**2022/1082**

Change of use of outbuilding to allow use for recreational activities as a personal trainer

12 Newark Close, Staincross, Barnsley, S75 6NN

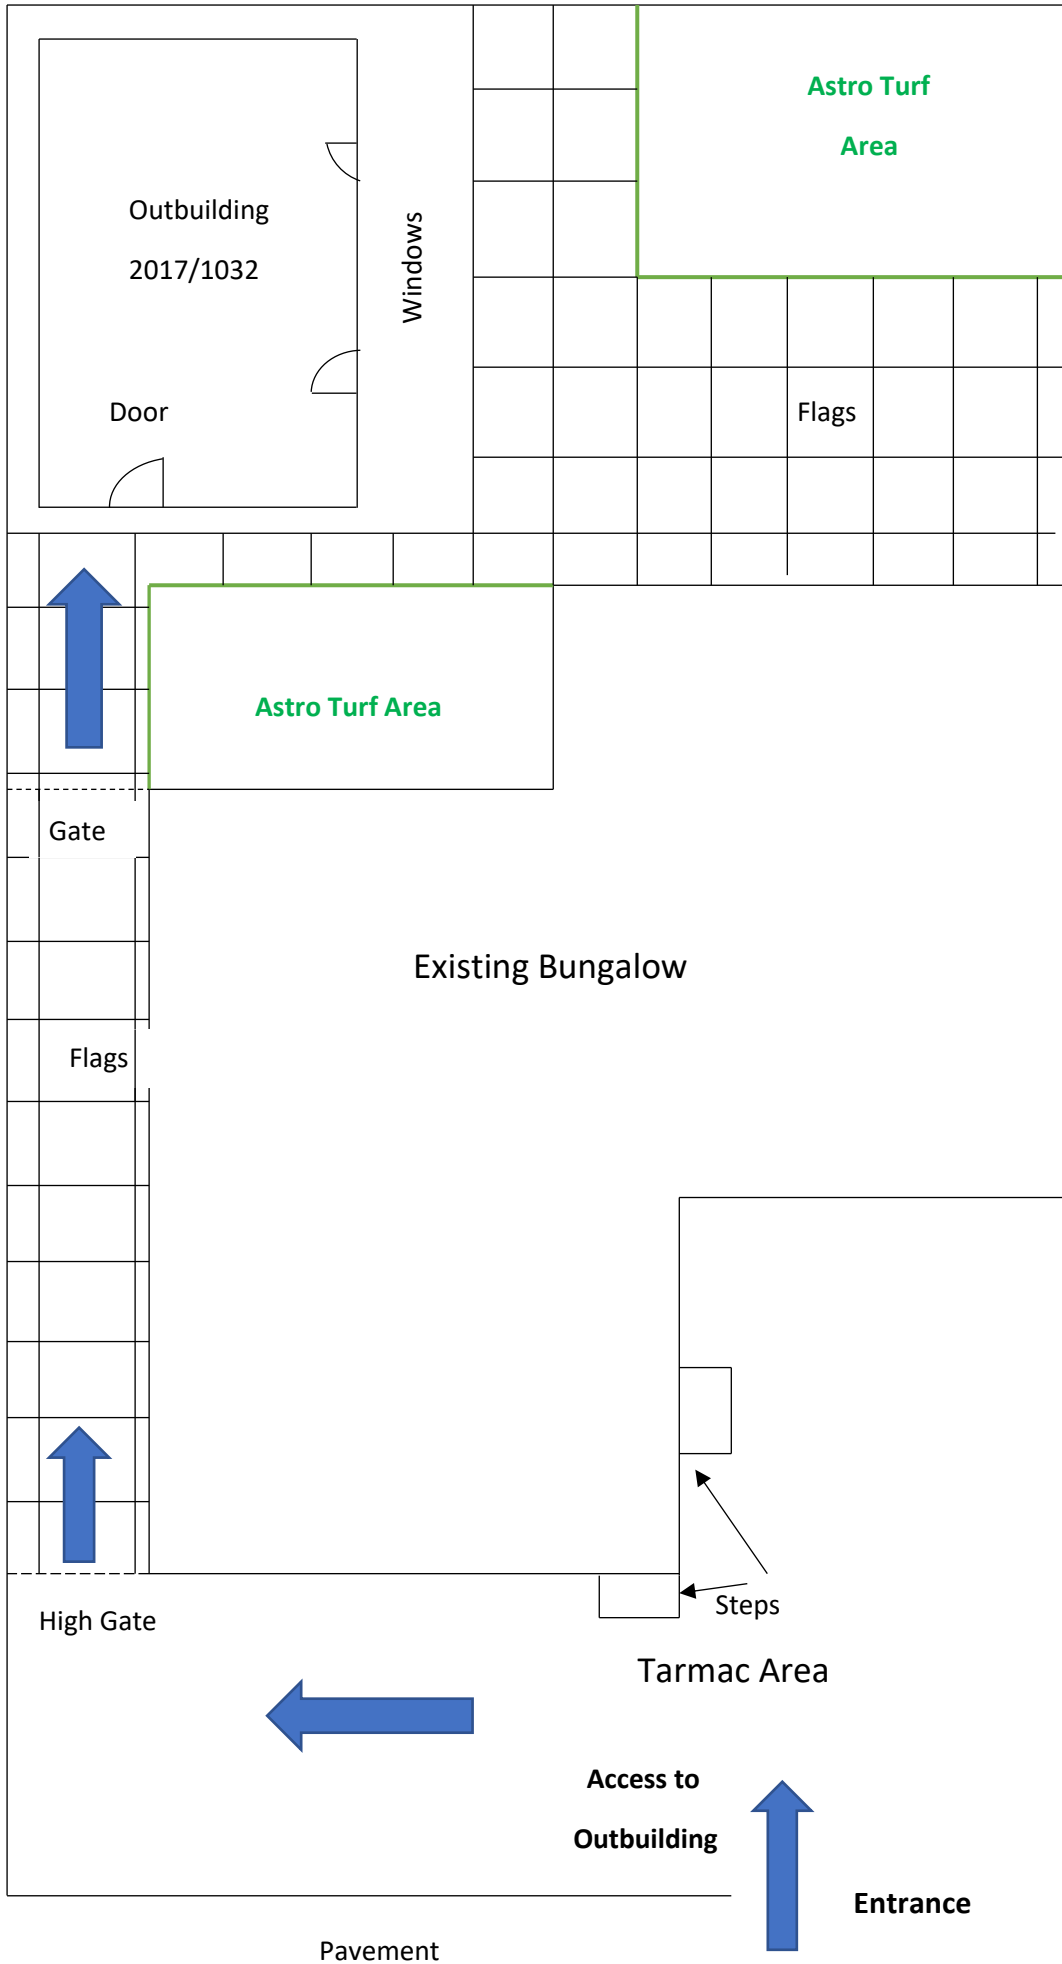
Upon receipt of additional information, highways retained their concerns that the proposed parking layout, lack of safe pedestrian access and lack of manoeuvring area was not considered to be appropriate to serve the proposed use. The proposed parking layout shows space for 4 vehicles, with the owners space to the right hand side, and proposed parking spaces to the left hand side. It is the Council's opinion that this arrangement is unacceptable due to the lack of safe external pedestrian access through/passed parking spaces 1 and 2 into the rear garden, and the lack of manoeuvring space. Specifically, owners parking 1 and 2 will directly obstruct the turning area for the proposed parking and result in much less than the required 6m aisle area. The applicant has argued that the space used in owner space 2 would never be used at this current time, however this does not include future use of the future tenants/residents and if the applicant's home situation changes. Equally, the applicant has indicated that they encourage clients to arrive by non-motorised means (running, cycling or walking), however this cannot be controlled by a planning condition.

There is general concern that the proposed parking arrangement, parking layout plan or the submitted information will ensure that clients can safely park on the proposed area, manoeuvre within the site and enter the highway in forward gear, which will very likely lead to clients parking on the road which is clearly an easier option and would not be controllable by the Council through a planning condition. The site is in very close proximity to a corner junction and parking on the road would have a detrimental impact on visibility for other road users.
